Recommendation Report for Planning Permission for Works or Extension to a Dwelling

REF NO: BE/1/21/HH

LOCATION: 37 Mansfield Road
Bognor Regis
PO22 9EZ

PROPOSAL: First floor loft conversion and rear extension for ground floor kitchen/living area with bedroom above. New open front porch.

PROPOSED FIRST FLOOR PLAN

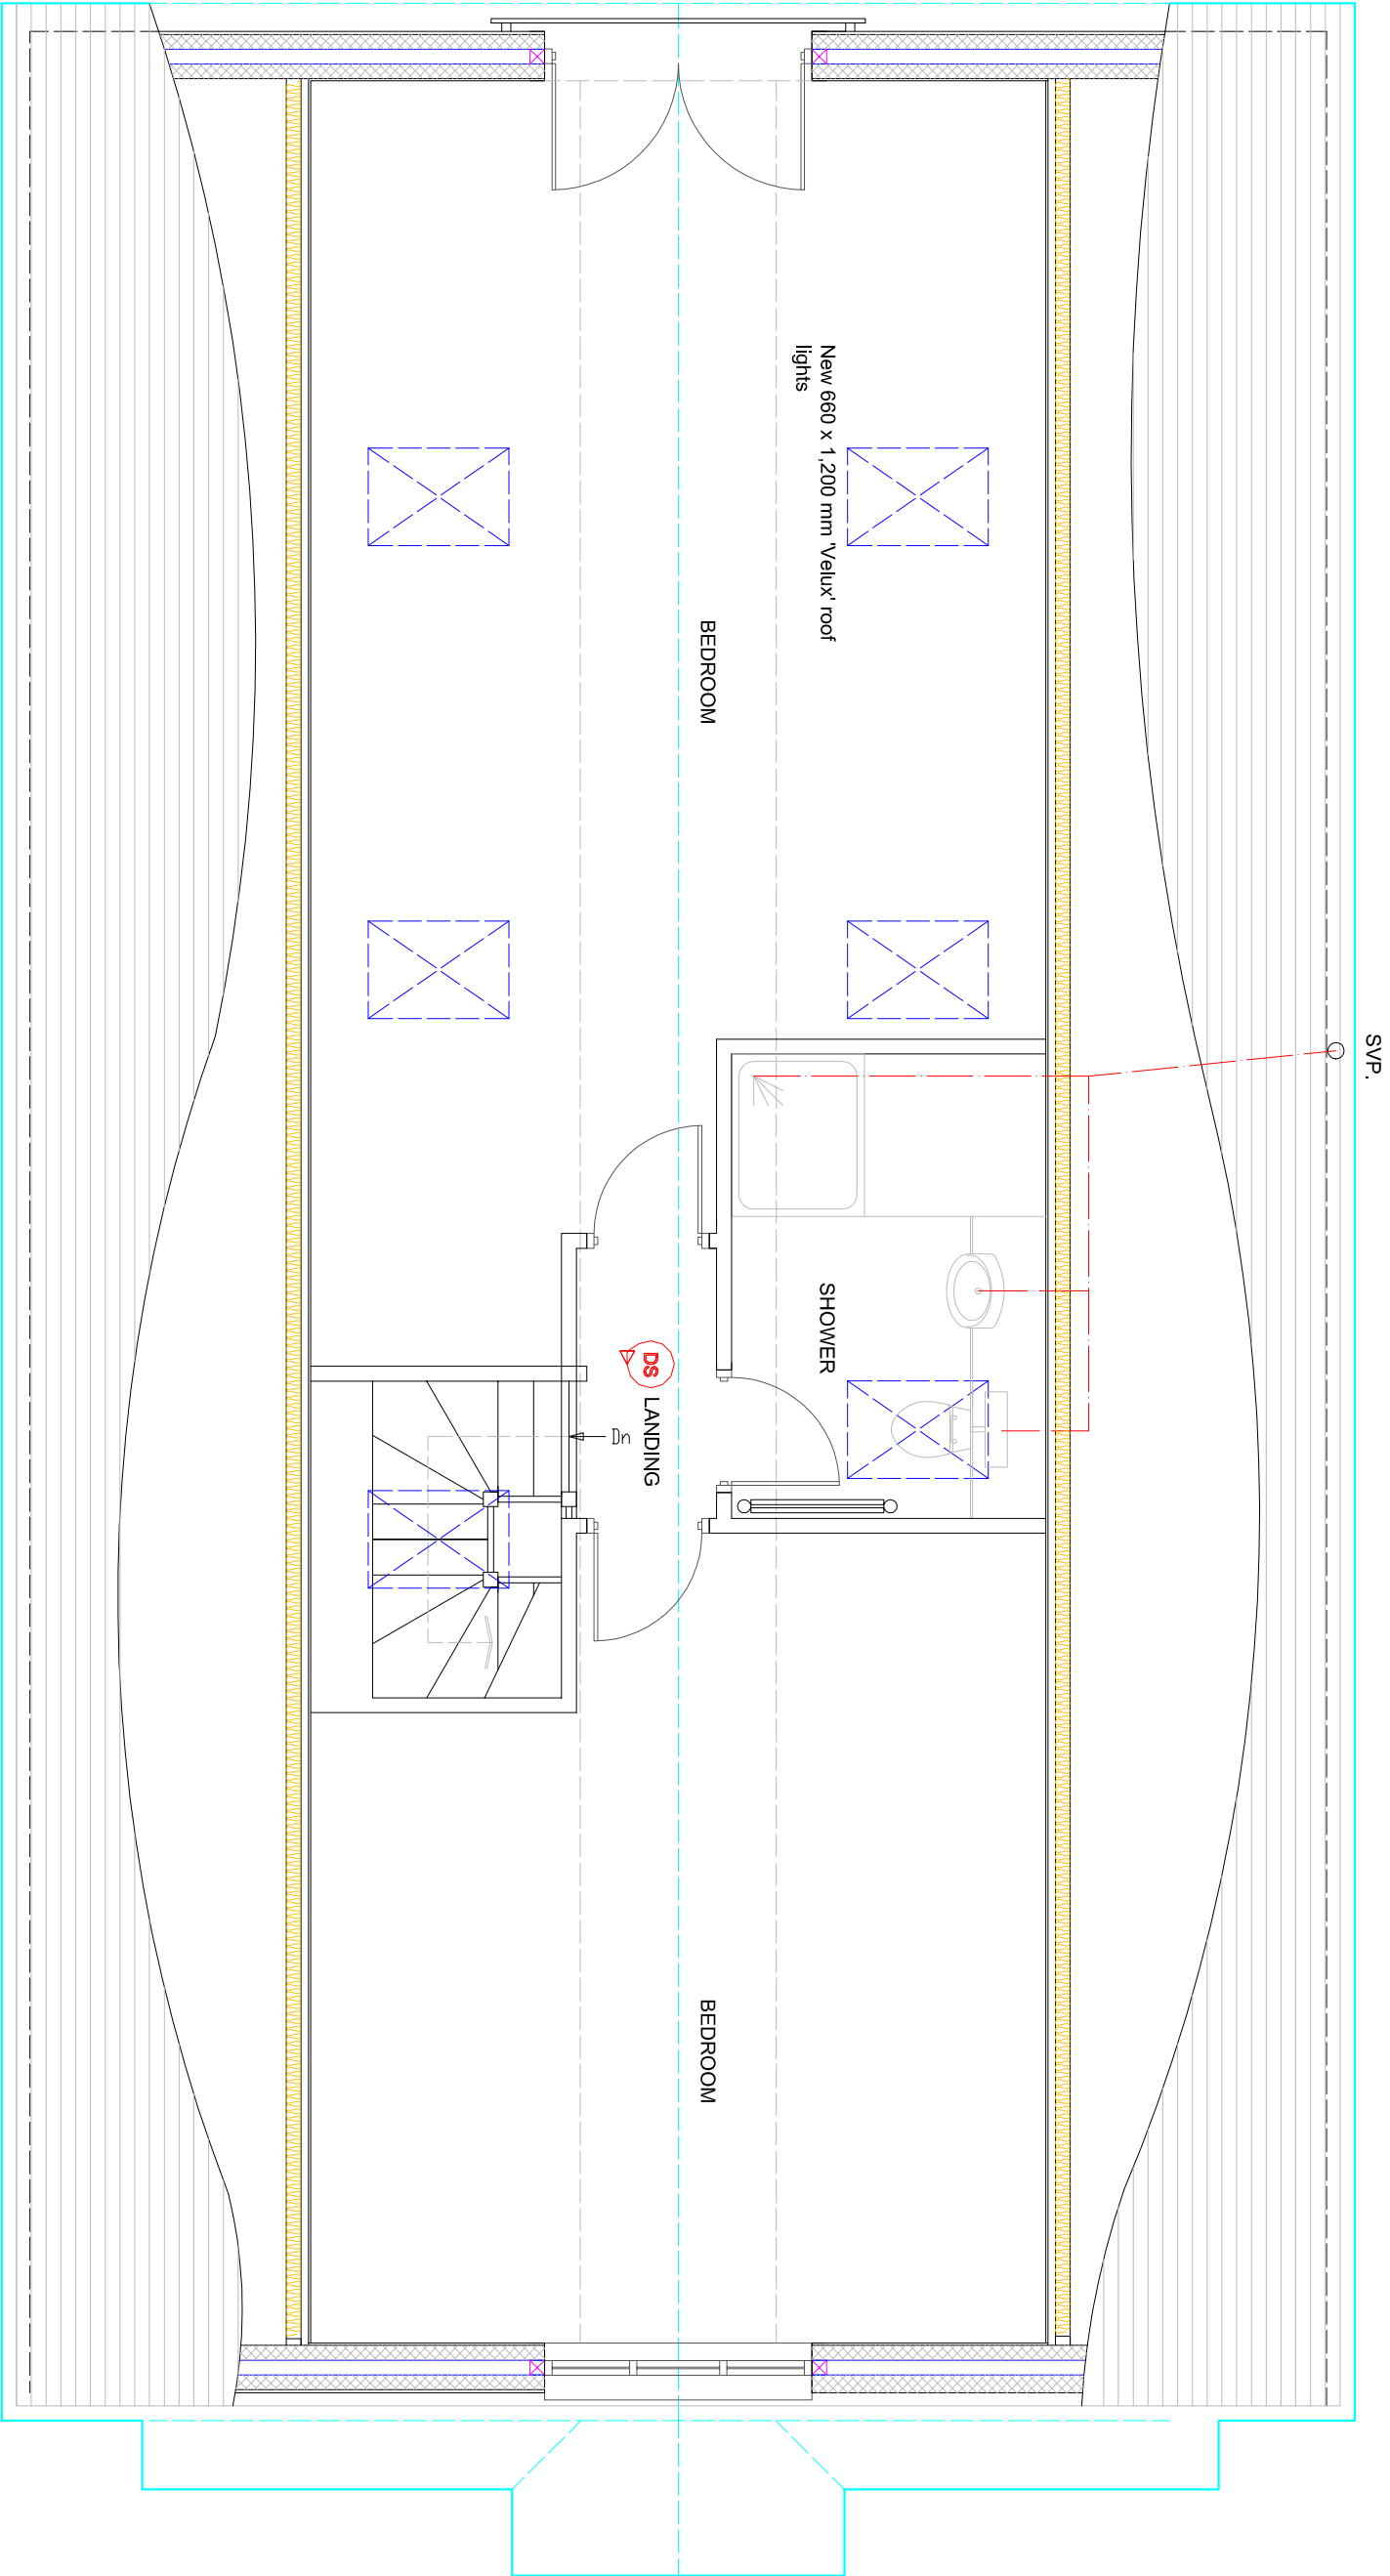
The development is not considered to result in any harmful loss of privacy to the occupiers of neighbouring dwellings because the Juliette balcony provides views to the rear of the development with

25.9m to the boundary this is ample to avoid overlooking to the rear. Other views available from the development are not considered to result in any significant harm to local occupiers, in that they are similar to those from the host dwelling at current with the use of the 'velux' style windows. Whilst these windows will introduce a new view but given the potential for a rear dormer as permitted development this would not be so harmful such that we could refuse.

PROPOSED ELEVATIONS

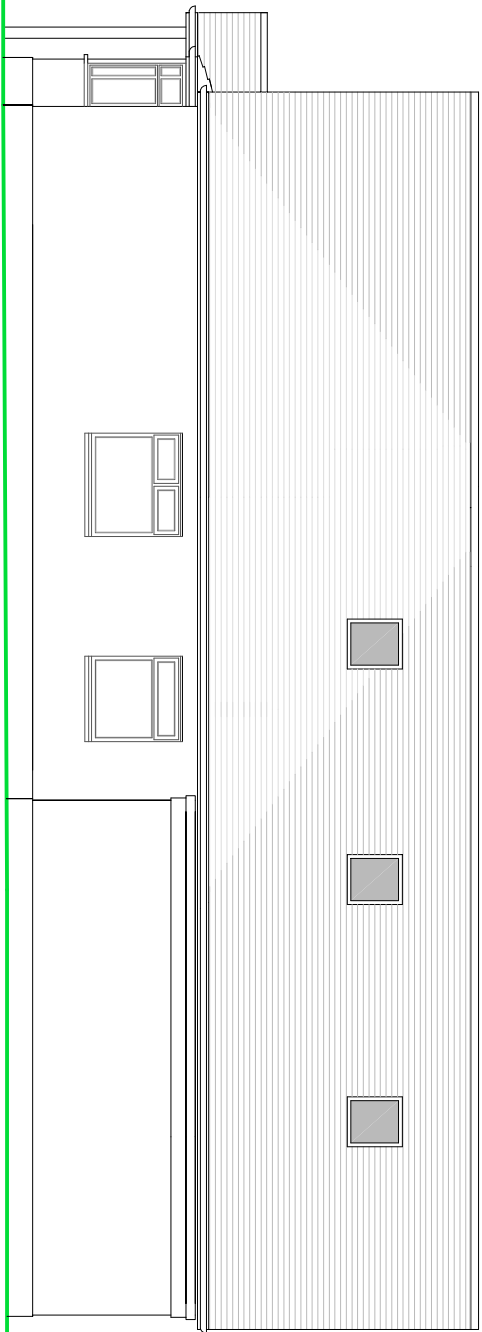
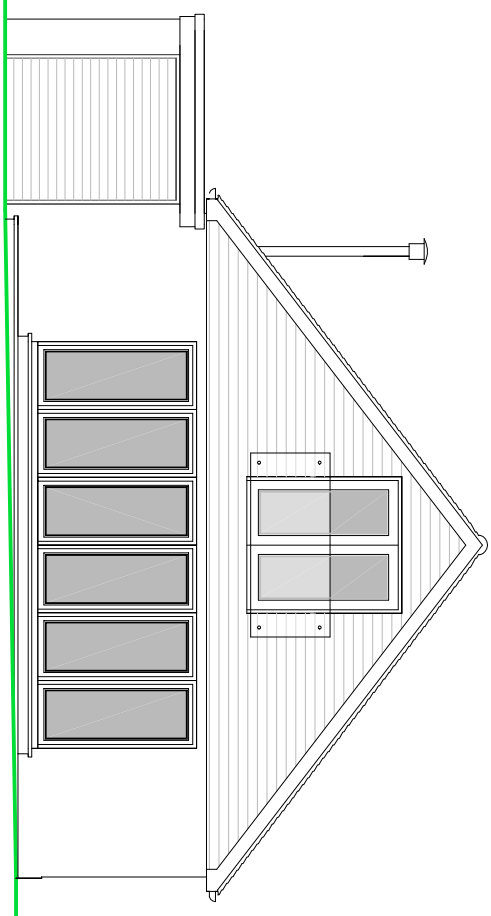
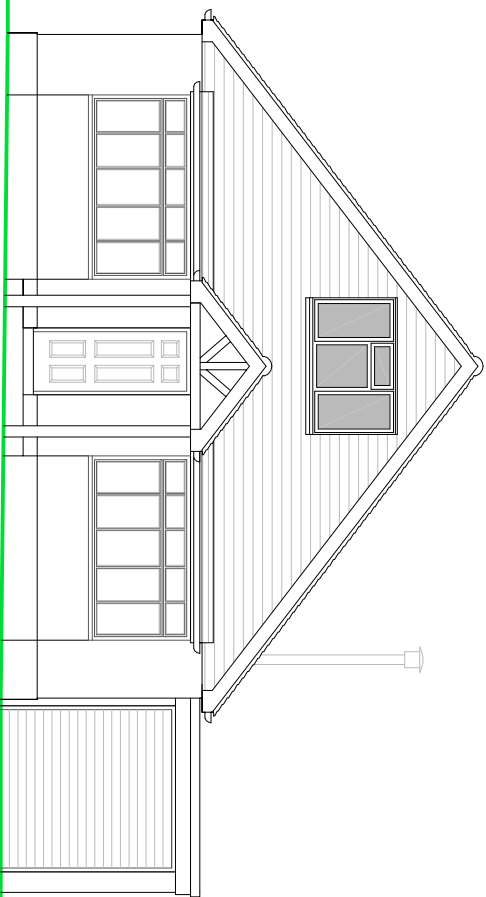
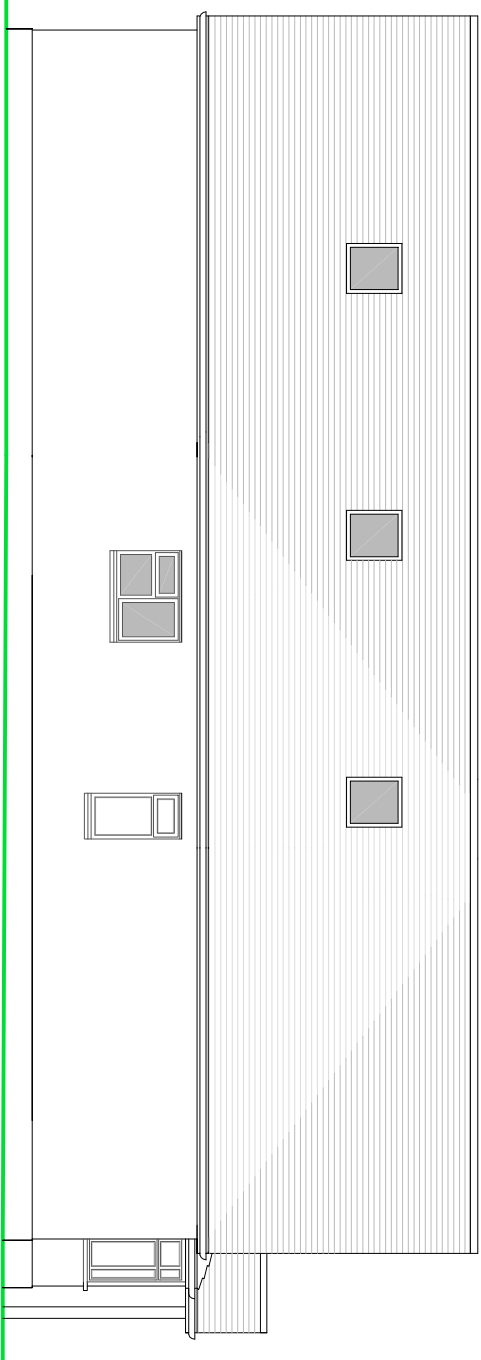
The development seeks to perform various extensions and alterations to the host dwelling. This includes a first floor extension and conversion of the roof space of a significant scale. As a result of the scale of the proposals, and the siting of the extensions, there is a change in appearance to the host dwelling, when viewed from the public realm and the street scene of Mansfield Road. It must be noted that this alone does not prescribe refusal of the application as it has to be established as to whether the proposal would result in any significantly harmful impact upon the host dwelling or its locality.

Additionally, the Arun Design Guide explains in section M that alterations to a dwelling house should compliment the existing character and appearance of the building and wider landscape. With other dwellings within the locality having dormers the proposed scheme is well integrated which is achieved through the simple design and unobtrusive form. As well as this the use of converting the roofscape through he hipped to gable and extension allows the proposal to further follow the design guide which specifies to the proposals should avoid large, flat topped alterations.

The porch has a depth of 1.2m and a width of 2.6m. It has a pitched roof similar to the design of the dwelling. The proposal appears subservient to the main building and well integrated with the dwelling.

The development is considered to conflict with D DM4(b) of the Arun Local Plan, the proposal accords with D DM1, DDM4(a) and (e) of the Arun Local Plan.
